Subject: RE: GTR Fontwell Drainage Condition 12

Drainage Engineer

Engineering Services

Attenuation is to extend minimum of 0.5m into gravel layer.  
Borehole details  
Gravel layer 23.45mAOD to 20.15mAOD over Clay layer below at least 4.5m thick (to end of borehole).

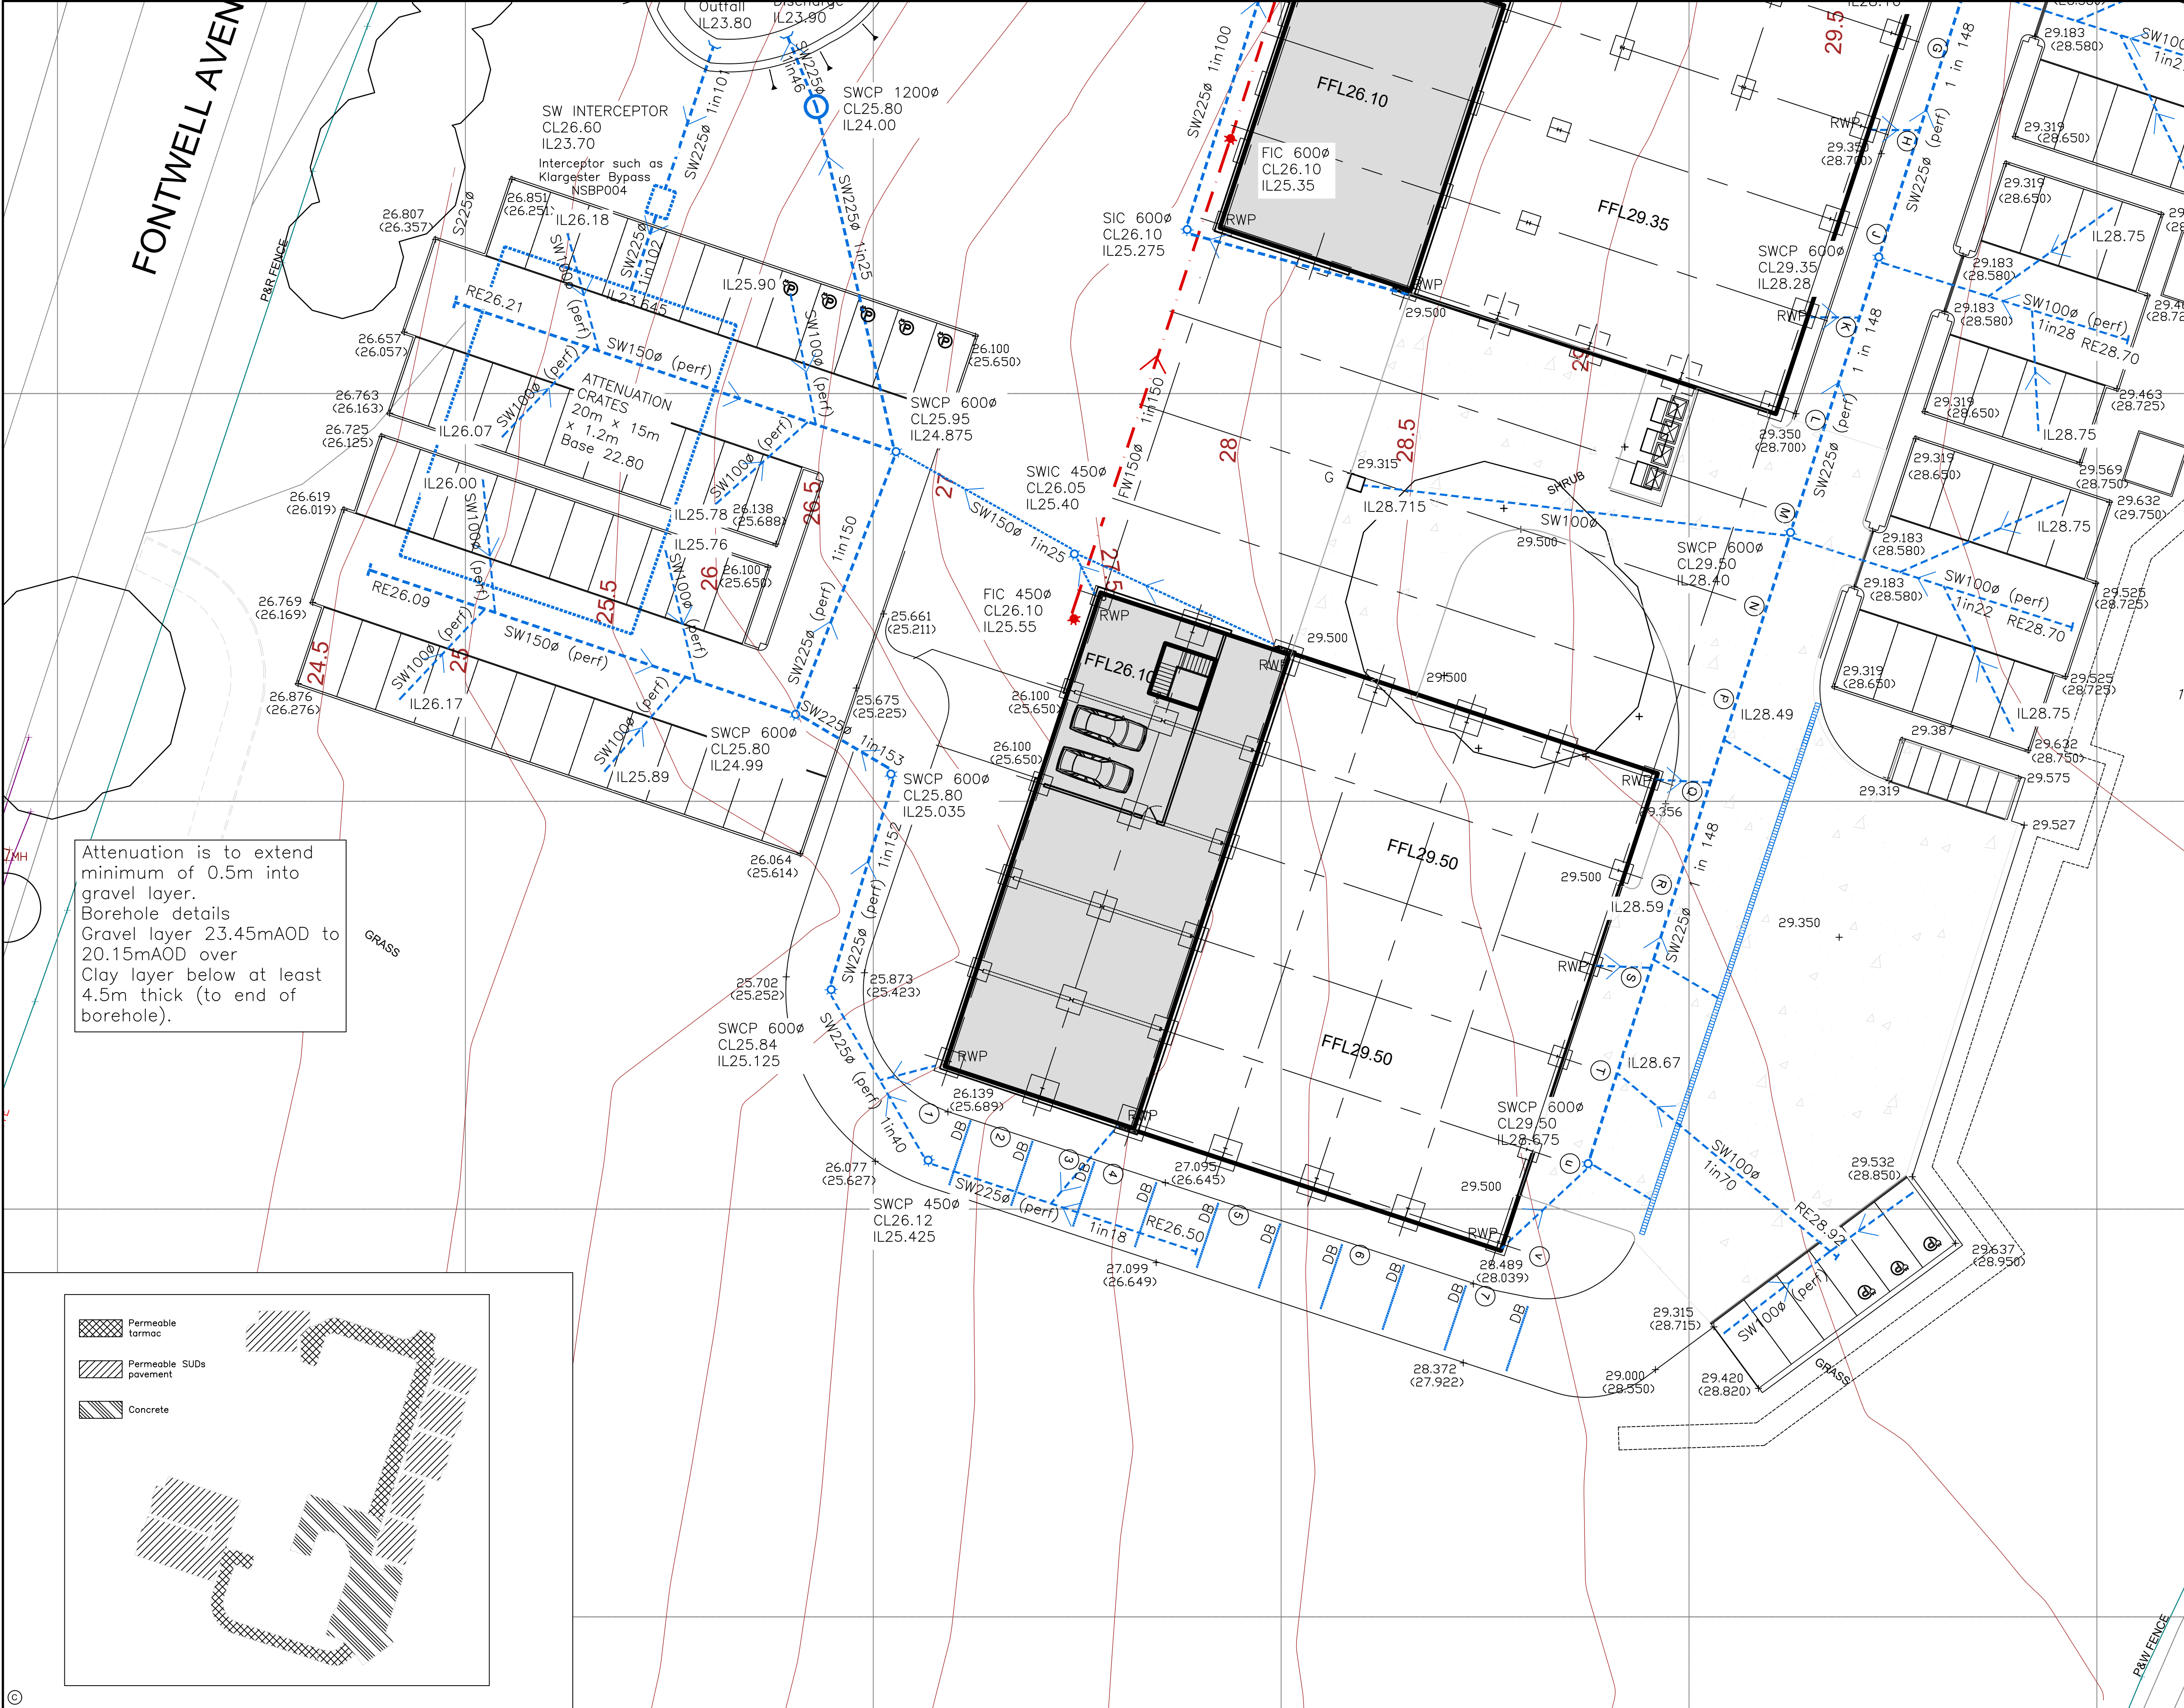
1. Permeable paving extents need to be more clearly defined on drainage layouts.
2. Catchpits do not appear to be provided upstream of all connections into permeable paving sub-bases, perforated pipes and bases.
3. Calculation printouts should include cover levels.
4. Permeable paving areas should have cap volume depths applied in calculations.
5. Construction detail drawings still have not been provided.
